Application for Removal or Variation of a Condition following Grant of Planning Permission or Listed Building Consent

Excavation of a basement extension below the front garden, lowering of the existing lower ground floor and rear garden level, erection of two-storey glazed infill extension to the rear, reconfiguration of layout for the lower ground to first floor to create a single family dwelling. Landscaping works of rear yard and new stairs to glazed infill extension. Alterations to the front lightwell including relocating the stairs and landscaping the front garden.

We would like to substitute the approved drawings (379-PL100 Rev 1; 379-PL200 Rev 1; 379-PL300 Rev 1; and 379-PL301 Rev 1) to proposed drawings which are numbered: 379-PL100 Rev 4; 379-PL200 Rev 3; 379-PL300 Rev 3; and 379-PL301 Rev 3.

Project		40 Northumberland Place, London, W2 5AS		
Title		Proposed Sections AA		
Date	26.11.18	Scale [A3]	1:100	Drawing no.
				379-PL300
Rev.				3

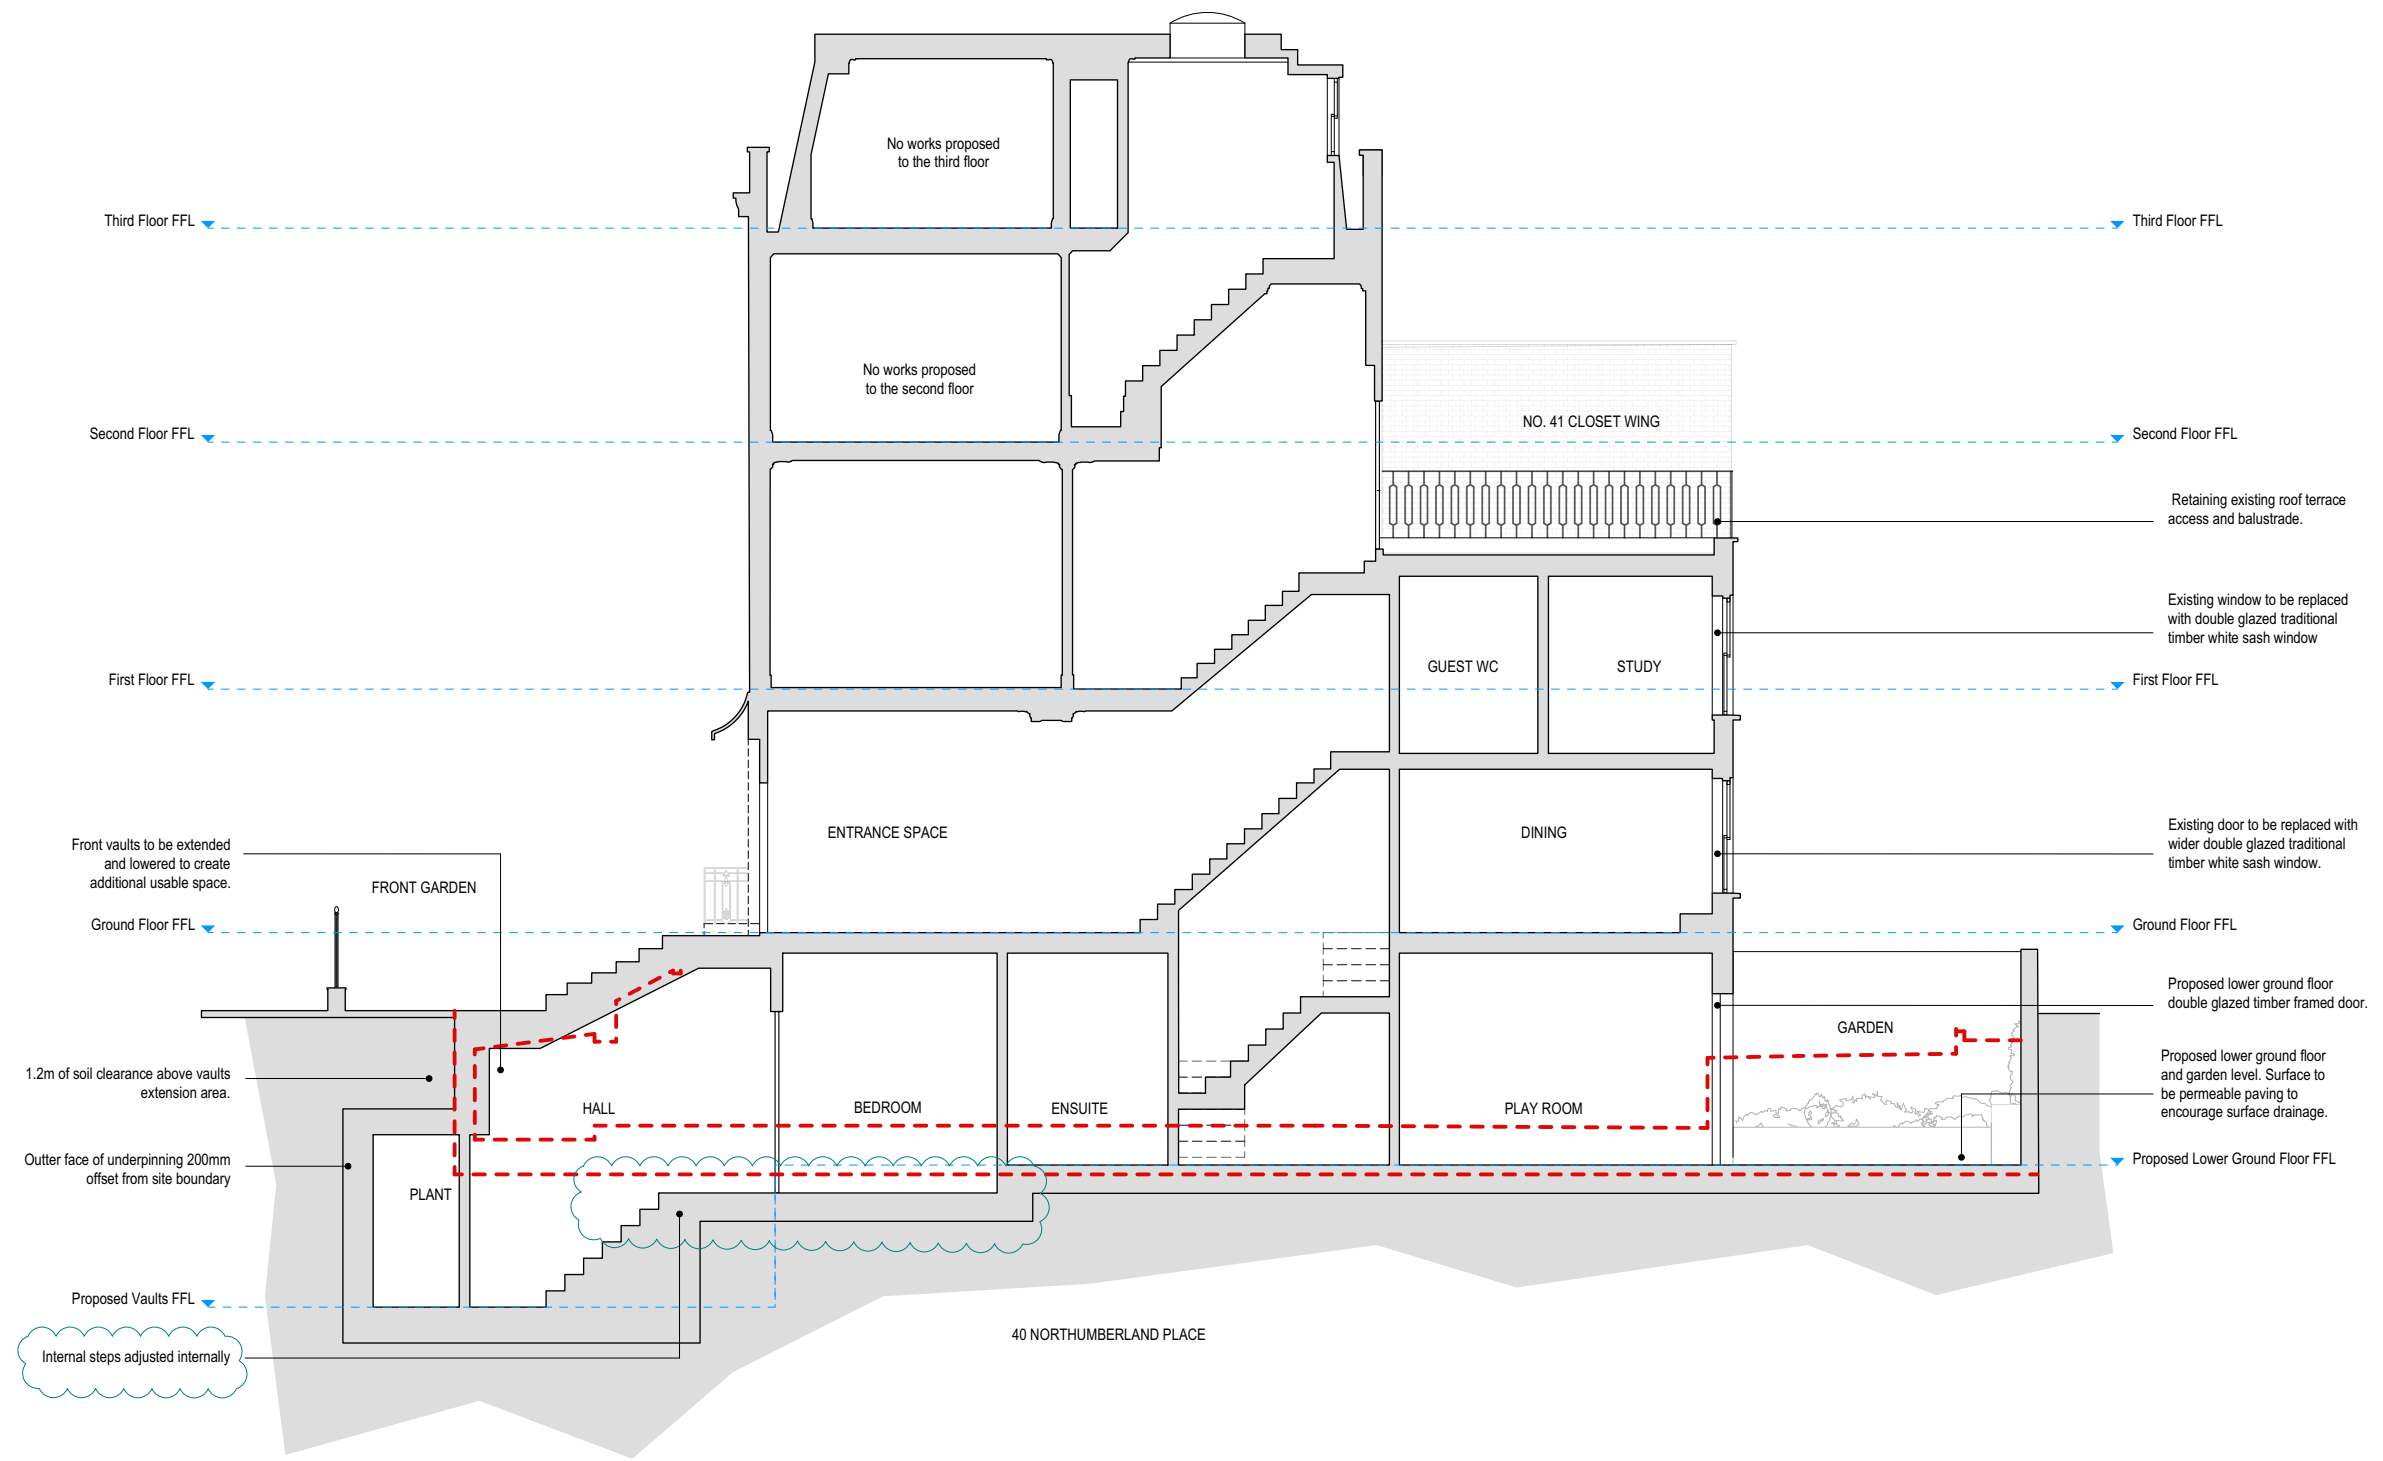
- Alterations to the front garden area including reducing the size of the lightwell, changes to the front entrance steps and repositioning of the bin store and planters;
- Changing the style of lower ground floor (secondary) front entrance door to include a fanlight;
- Rotating the rooflight to the glazed infill extension; and
- Adjusting the internal step arrangement to the lower ground floor and minor internal layout changes.
